**APPLICATION NO:** (Our Ref. 25-2020-3-1)

**PROPOSAL:** Tomago Resource Recovery Facility and Truck Depot (SSD-10447)

**PROPERTY:** 21D School Drive TOMAGO, 21F School Drive TOMAGO (LOT: 11 DP: 270328, LOT: 8 DP: 270328)

Following further review of the proposal and supporting information, Council makes the following comments:

TYPICAL SECTION OSD / INFILTRATION SYSTEM

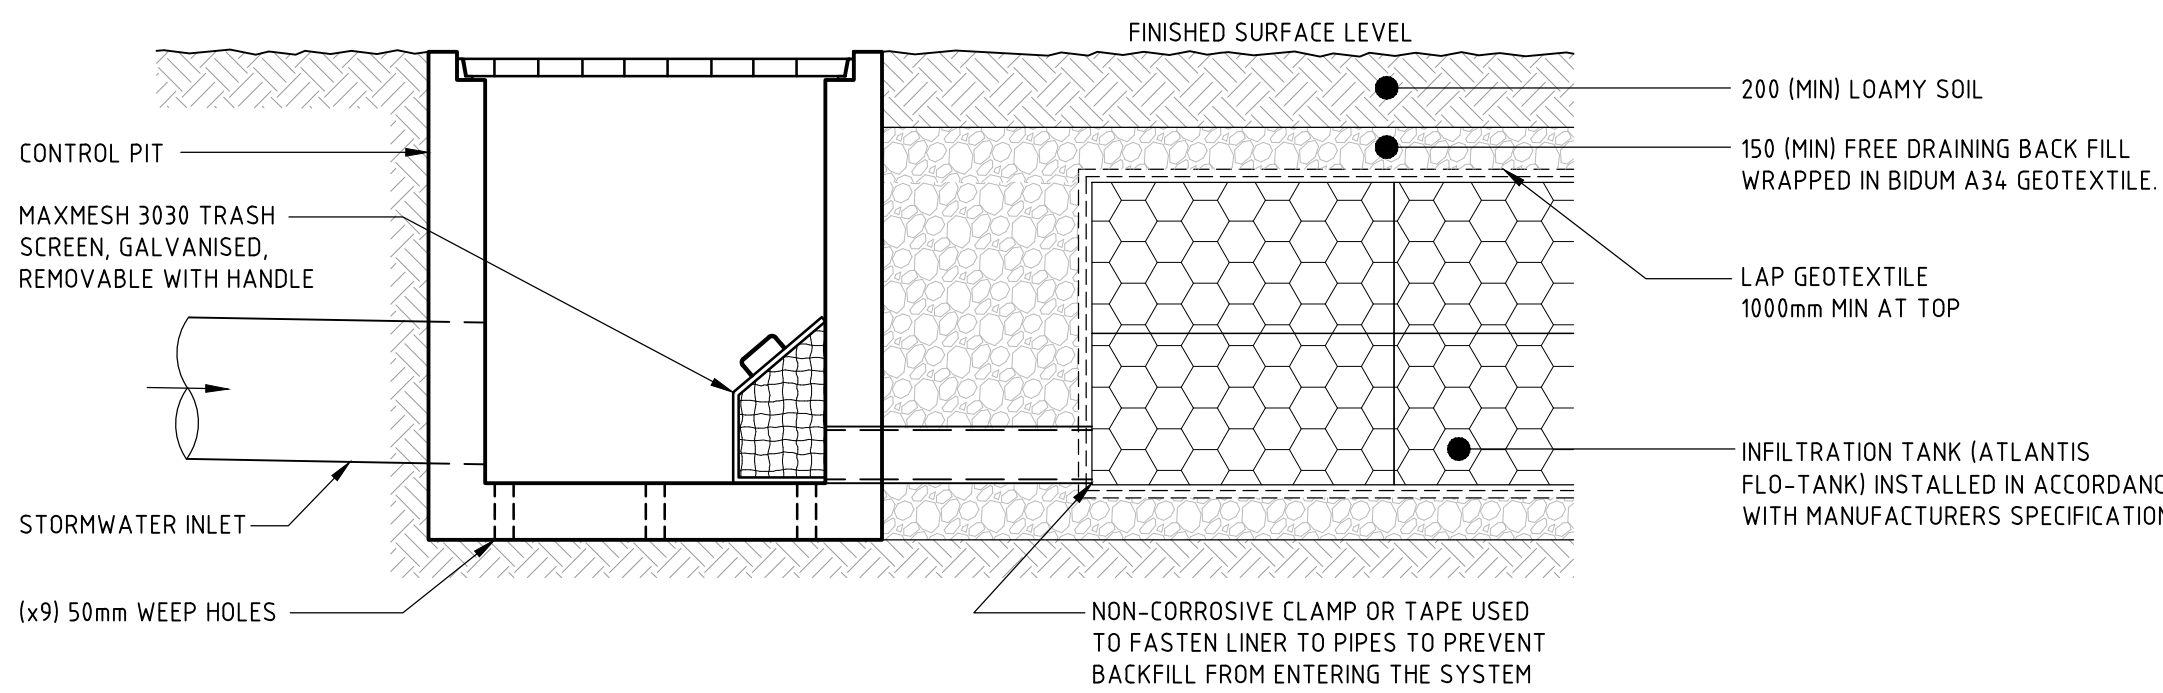
- **Stormwater Design** – The proposed stormwater design does not appear to be supported by any water quantity modelling. A Drains model should be provided to demonstrate the Infiltration system is designed to cater for all 1% AEP post development flows. The natural catchment has high infiltration and it is believed that the subject site won't produce any significant runoff even for the major storm events. Accordingly the Drains model should use the assumption that the pre-development flows, for up to and including 1% AEP event are zero
